Planning Inspectorate your reference :- EN020002

Dedham Vale East Cable Sealing End Compound

ALTERNATIVE SITE SUGGESTION FOR THE DEDHAM VALE EAST CABLE SEALING END COMPOUND

Drawing file: EN020002 / EN020002-000521-2.11.5 Design and Layout Plans Dedham Vale East Cable Sealing End Compound.pdf

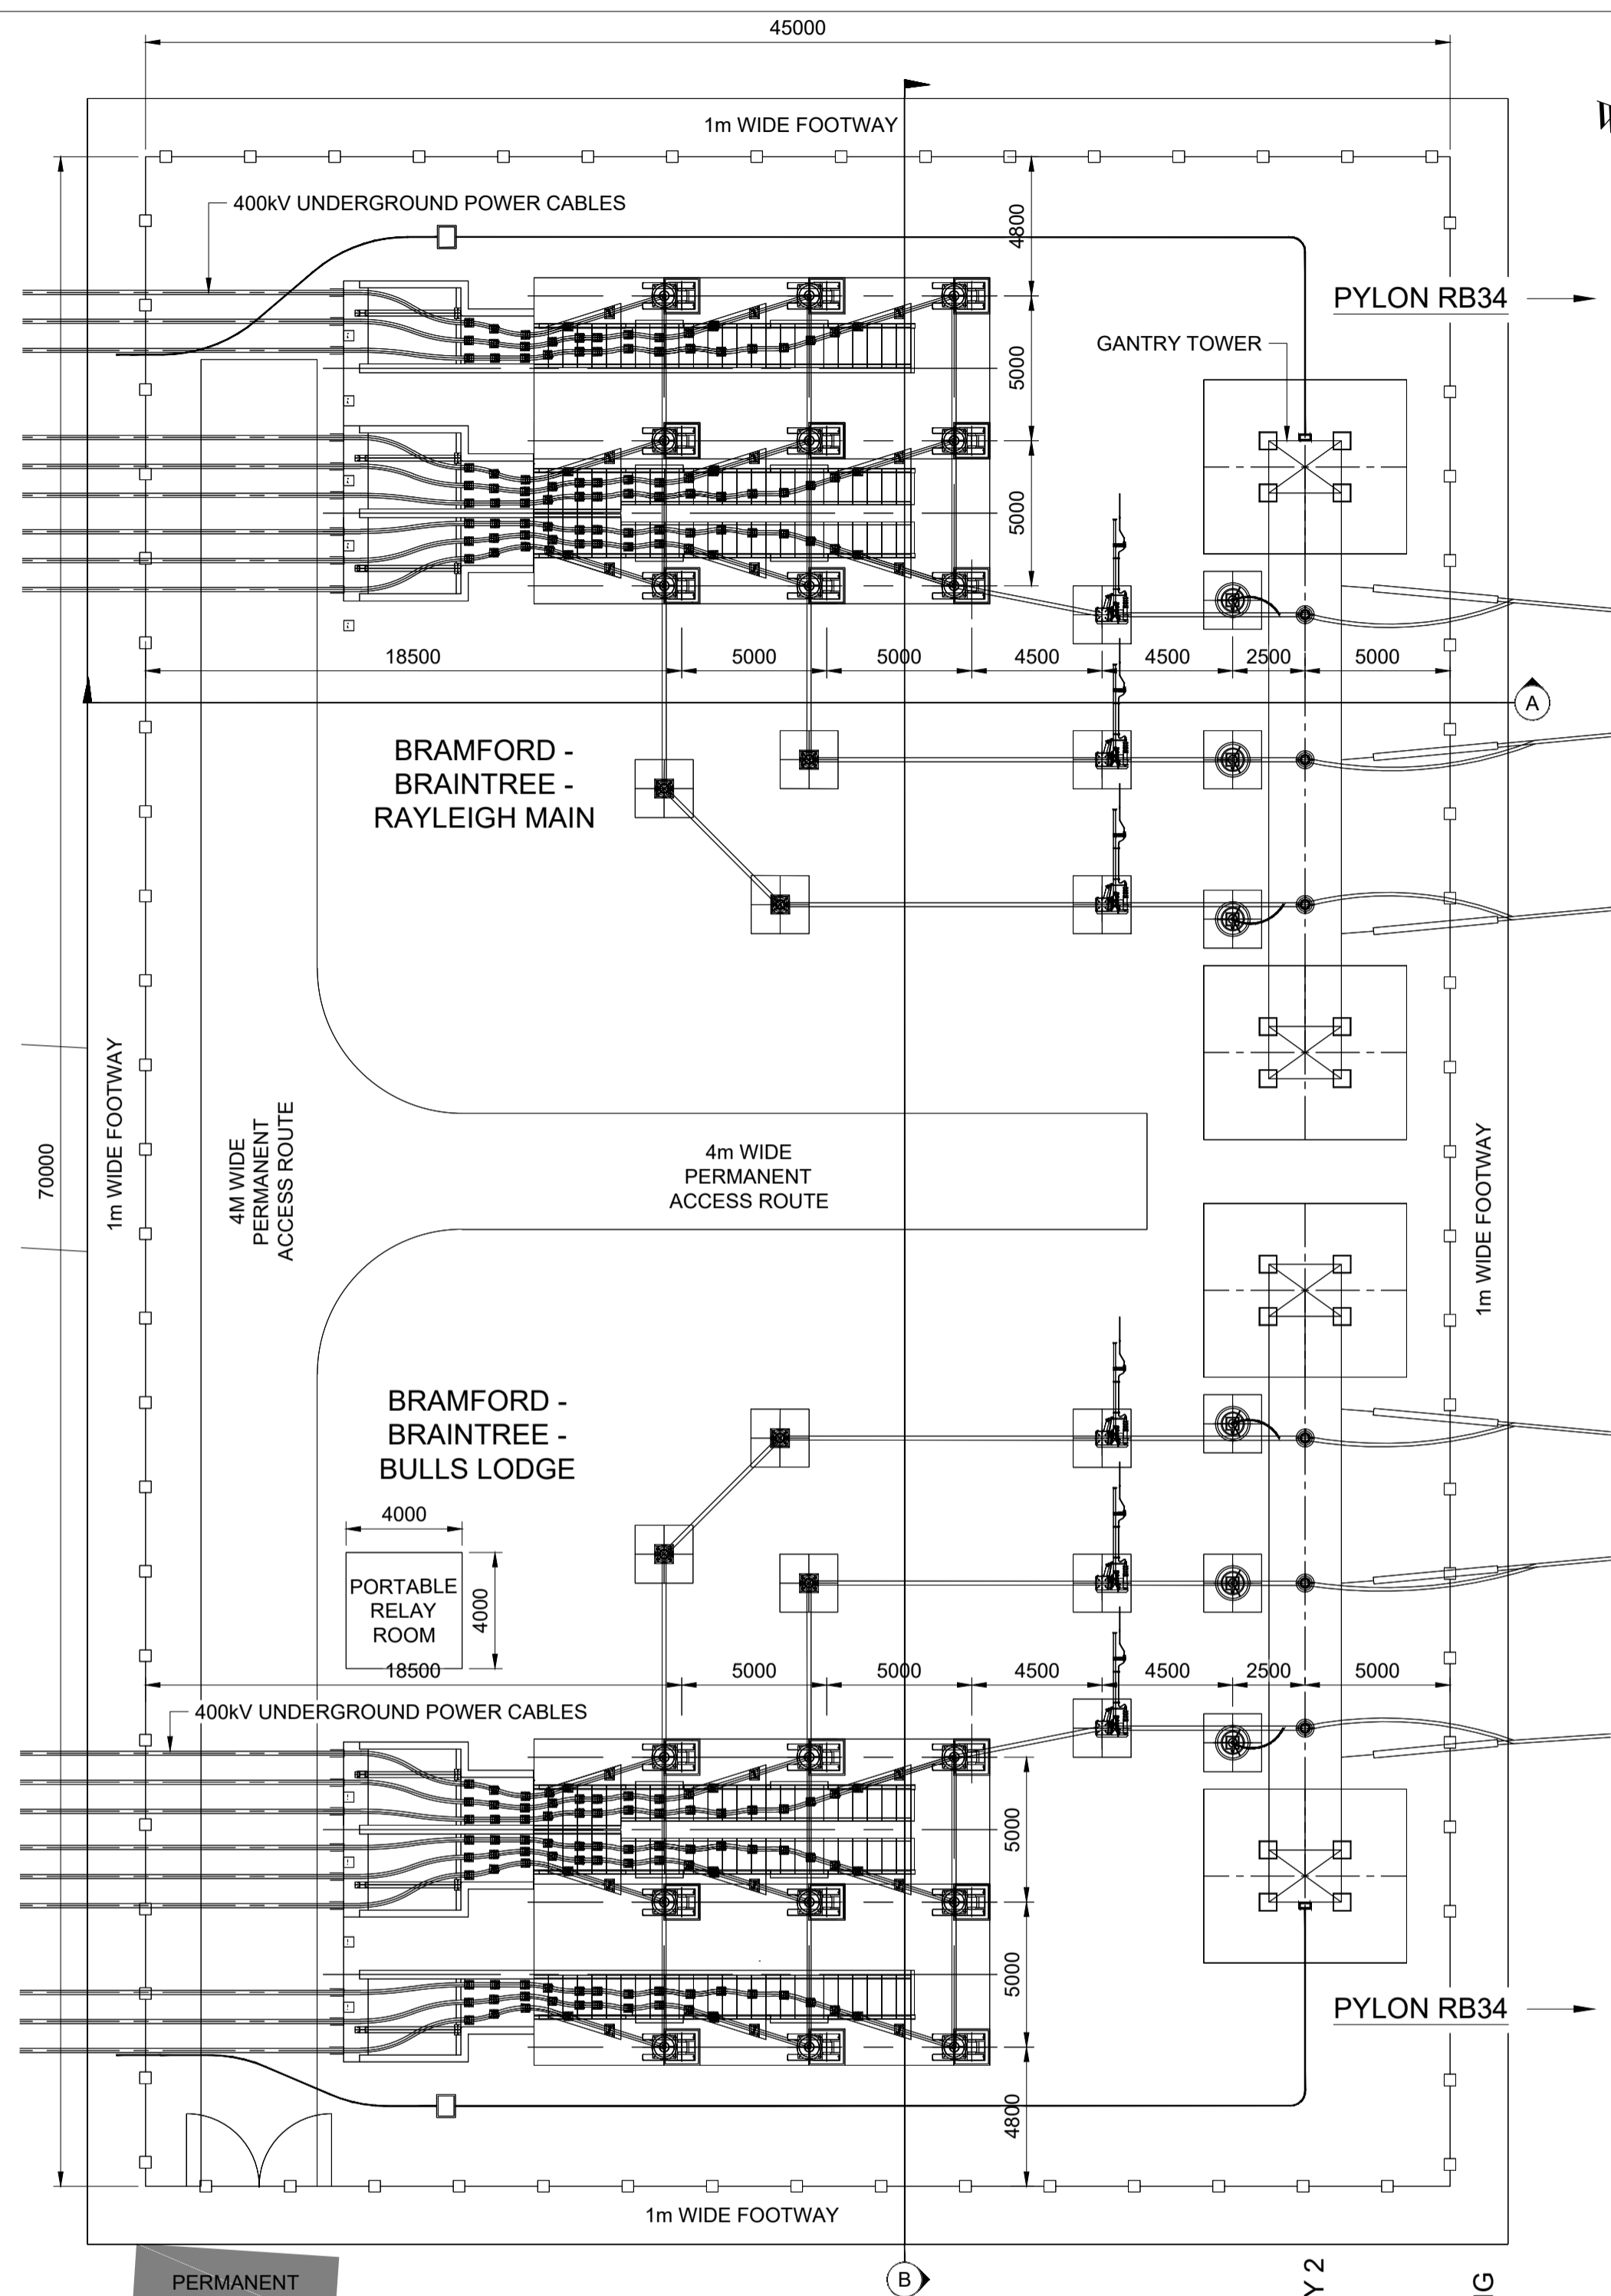
This written representation is to disagree with the location of the proposed **Dedham Vale East Cable Sealing End Compound** on Millwood Road and to propose an alternative site.

The alternative proposed site in the nearby disused gravel pit has significant advantages over the Millwood Road site in every category of the **'Initial Assessment of Principle Issues'**. The land in between the two sites is level and in a straight line so in terms of trench construction, this is a straight forward minor addition in length to the underground trenching with no technically difficult engineering problems.

6. Draft Development Consent Order (dDCO)	
7. Good Design	
Holford Rules	
Rule 3 – <i>“Where possible chose inconspicuous locations for angle towers, terminal towers and sealing end compounds.”</i>	
MR is in direct public view from highways and footpaths.	This site is totally hidden from any public view.
Horlock Rules	
Section II , Number 10 – <i>“.....a range of system and siting options should be evaluated and documented as part of the selection of the preferred solution....”</i>	
If any other options / sites have been considered they have not been noted. This proposal is for a more suitable site, a disused gravel pit, rather than a very visually open site on good agricultural land.

MR access is off a minor lane. The open nature of this site means that perimeter fencing would be obvious and only some additional planting on arable land could be used to mitigate the sealing compound.	There is very good access to the road from the A1071 to the DGP on the old two lane access road directly to the site. The isolated location of the site means that this guideline can easily be adhered to.

13. The Water Environment	
This field is level and is currently free draining. Any construction on this site would require water to be removed, there are no existing ditches in which to guide water away from this field.	This land is all free draining and since the extraction of gravel, slopes to the East allowing the site to be easily drained through the existing large drainage channels which have been dug to keep the site drained.
